Our Ref: LU/159/19/PL
Your Ref:

Town & Country Planning Act 1990 (as amended)
Town and Country Planning (Development Management Procedure) (England) Order 2015
Application for Planning Permission

Development New maisonette over parking area, extend crossover & alterations to rear fenestration.

Location 2 Croft Cottages Pier Road Littlehampton

Location Plan: 1:1250

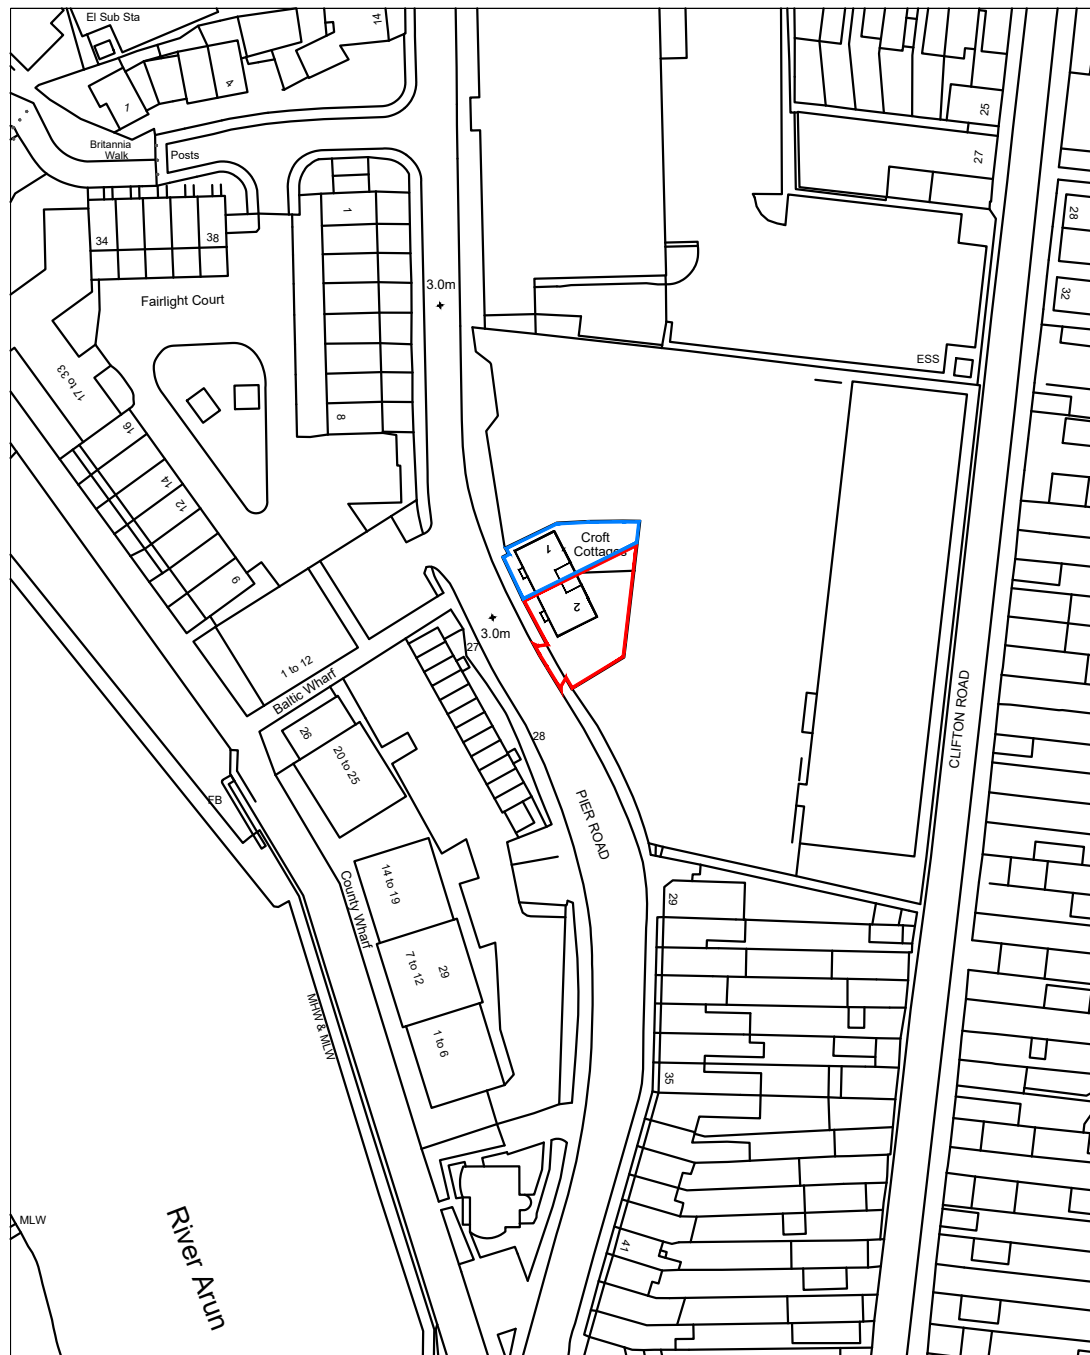
Location Plan Amend

Please include within the red edge the new part of the garden for 2 Croft Cottages.
